September 25, 2018
MVEA Yoder Substation Subdivision Exemption – EX 18 001
Applicant Comment Response Letter

GRADING, EROSION & SEDIMENT CONTROL PLAN
FEBRUARY 2018

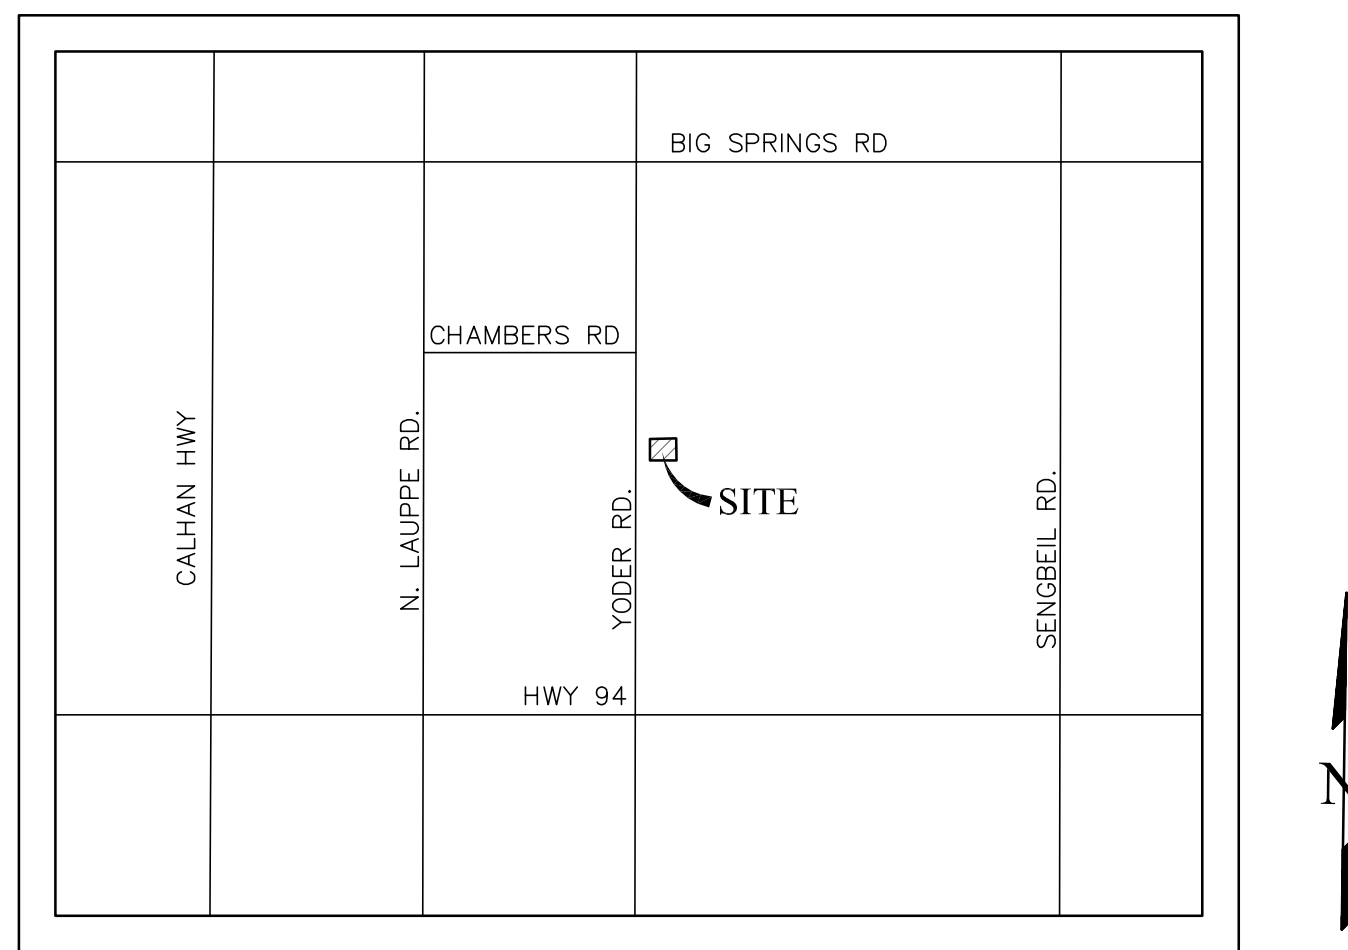
Grading Erosion Plan:
Page One
Water Control Plan changed to Sediment Basin Depression
EDB statement has been removed from Phase 2 Activities
Right of Way statement removed from Phase 4 Activities
Owner signature requested on plans – Noted
Statement regarding Receiving Waters corrected

MVEA YODER SUBSTATION
& SEDIMENT CONTROL PLAN
GRADING PLAN

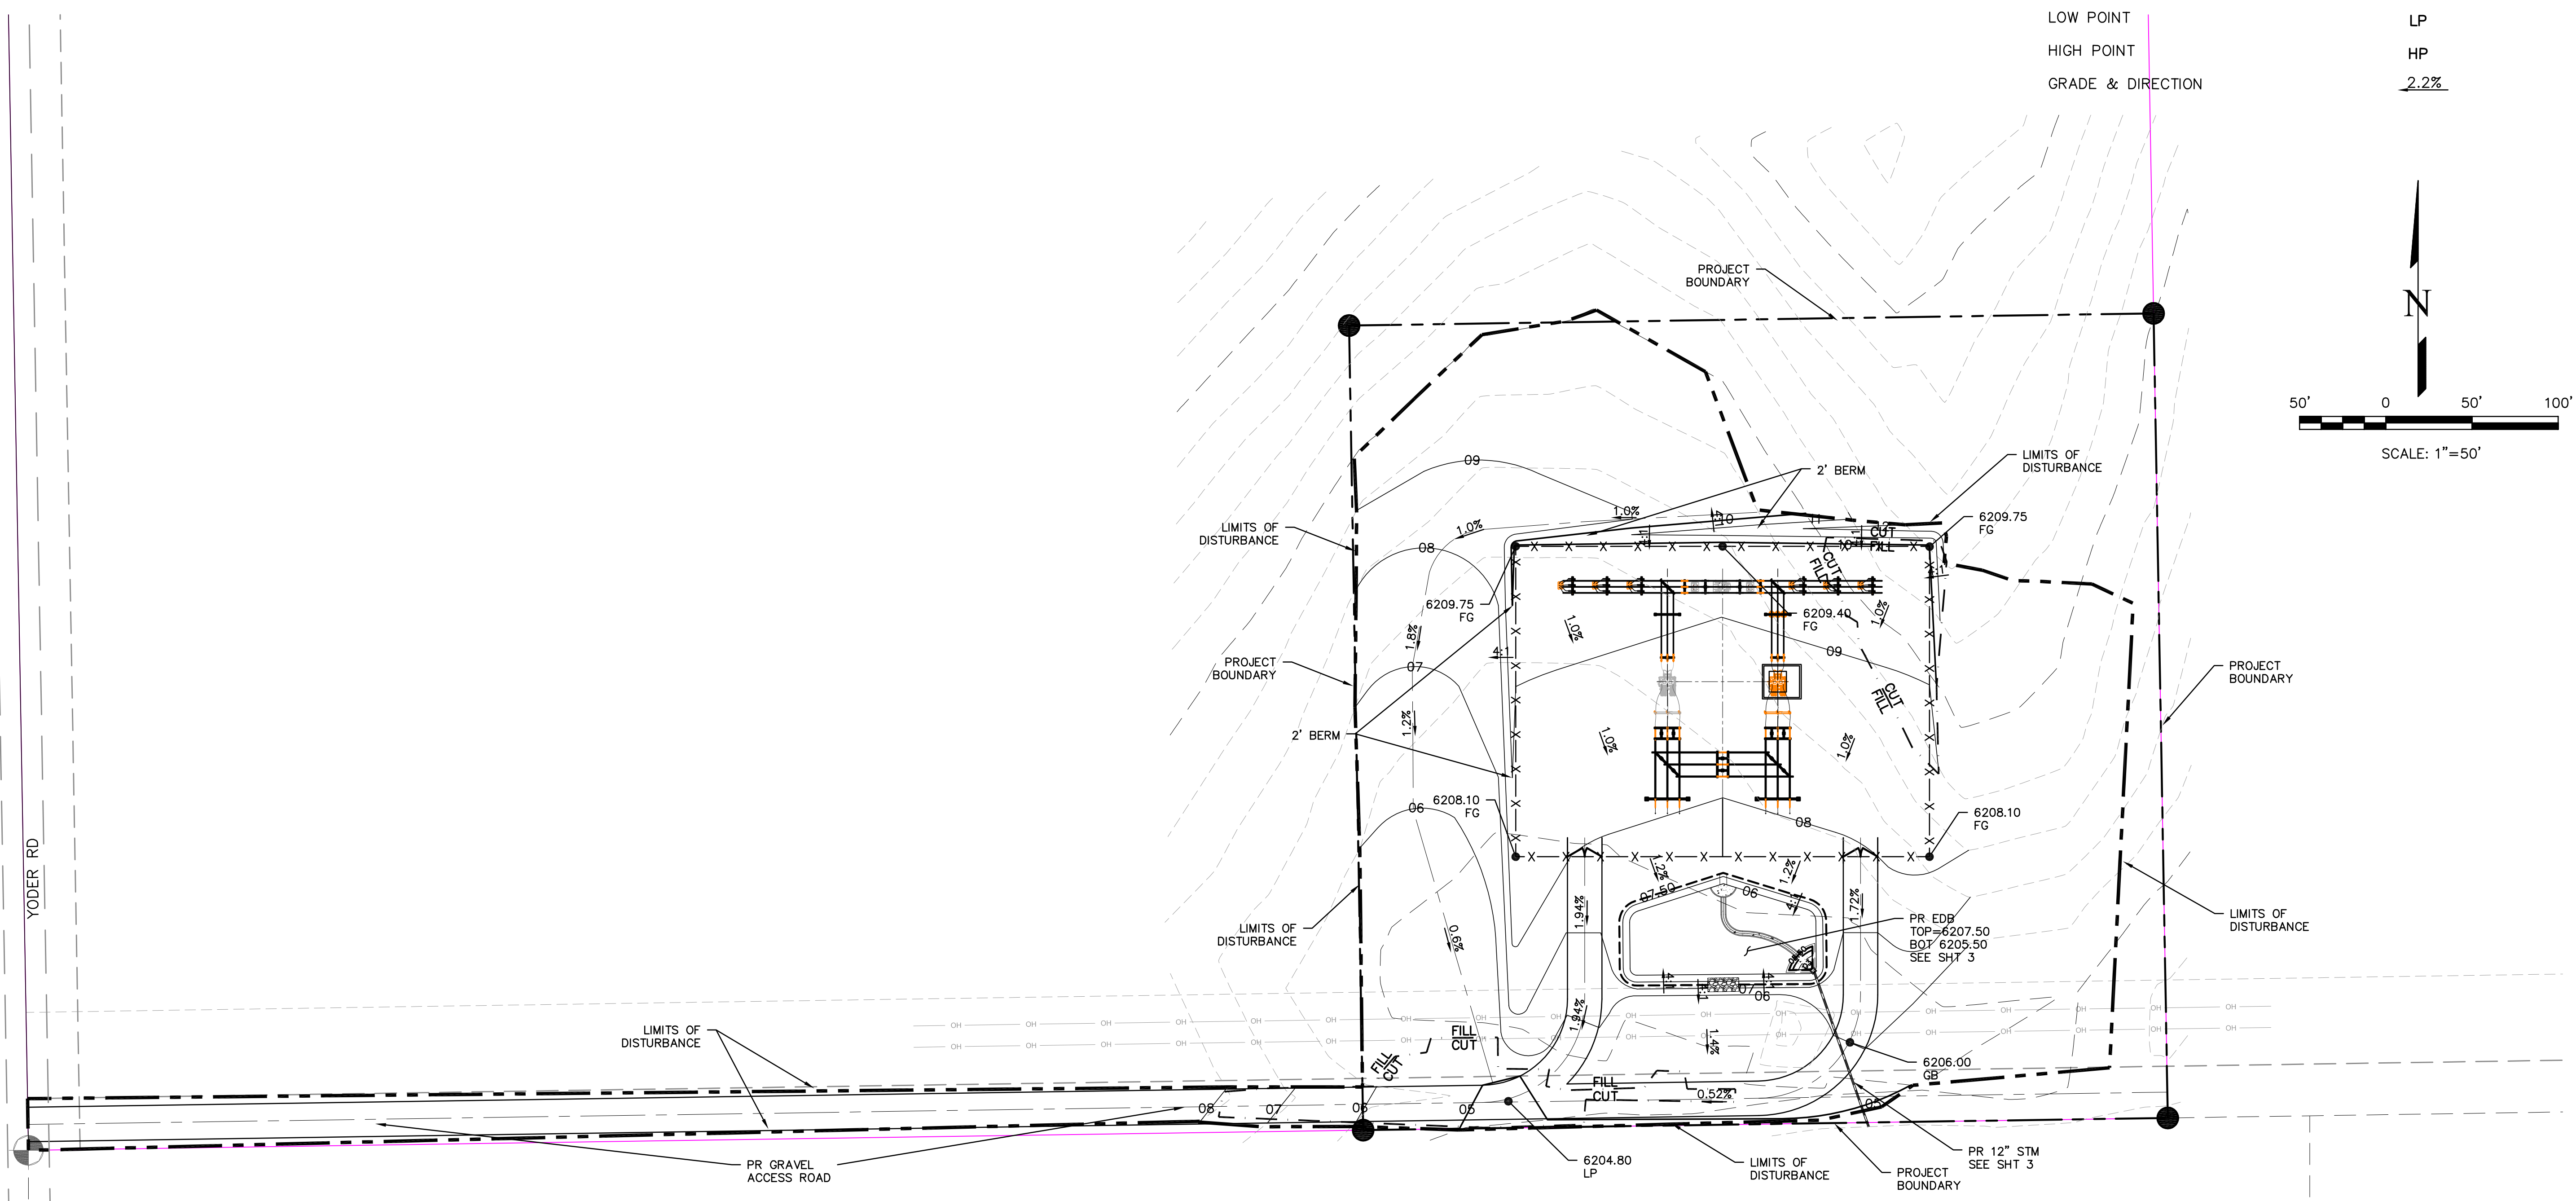
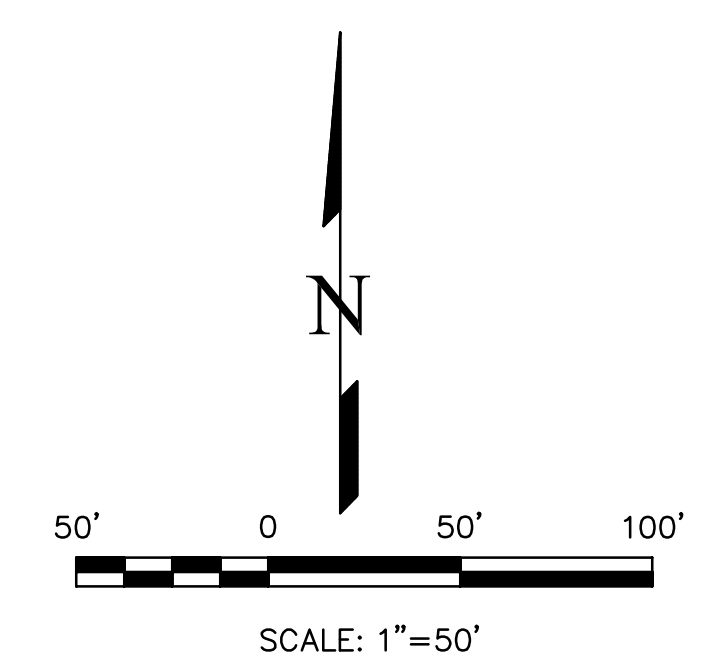
Page Two
Statement of flows along the southern property line to the Sediment Basin corrected

MVEA YODER SUBSTATION
GRADING, EROSION AND SEDIMENT CONTROL PLAN
EROSION CONTROL PLAN

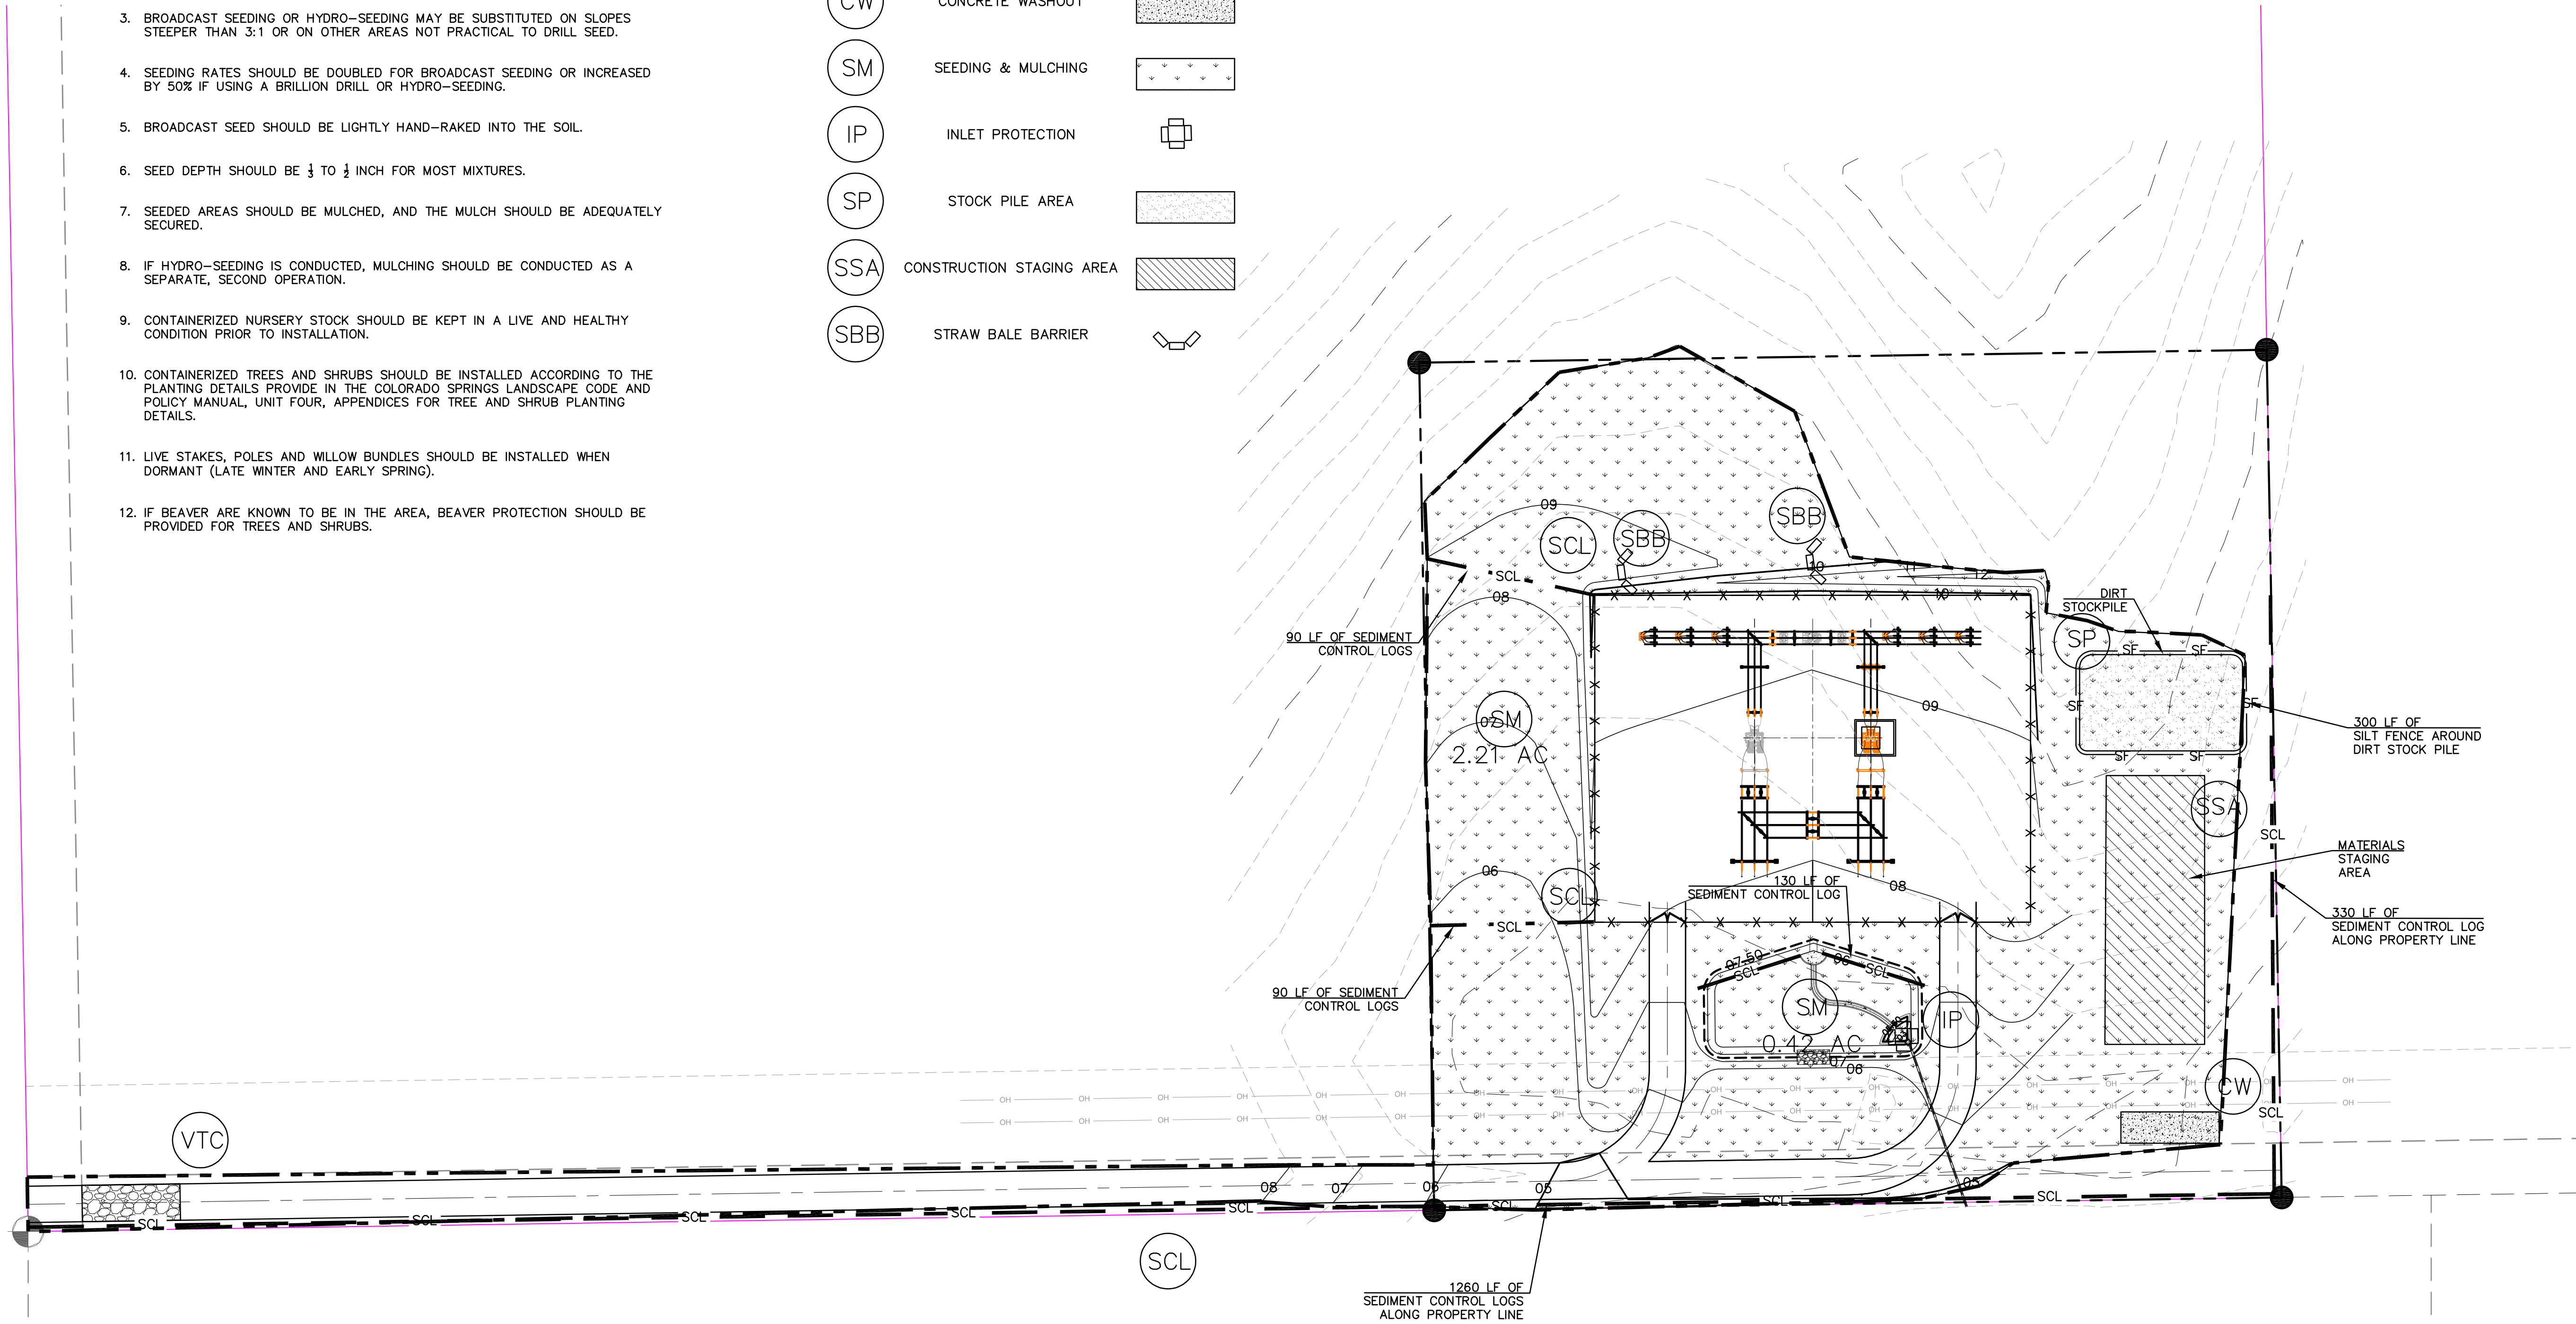
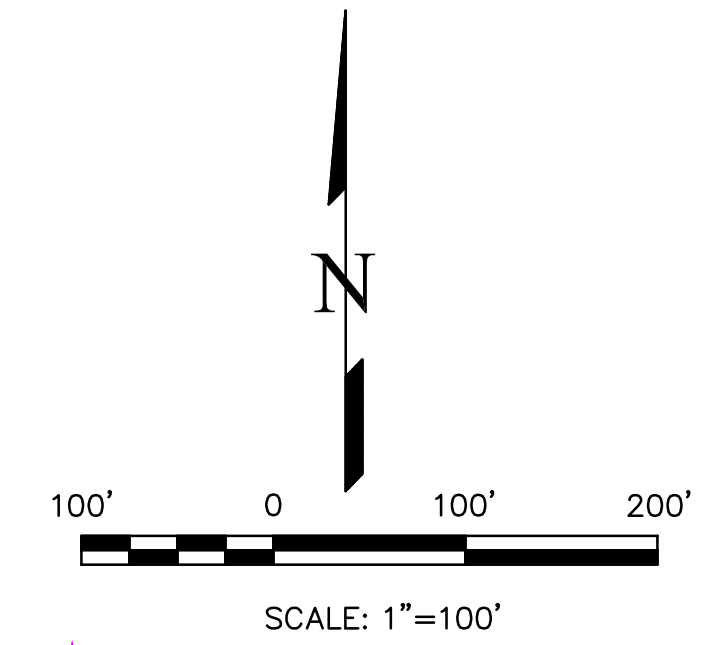
Page Three
Erosion Control Legend corrected to El Paso County
Re-Vegetation notes to remain for landscaping
Additional Contour lines added
Concrete washout moved away from property line
Offsite area shown to see limits of disturbance only. No easements required.
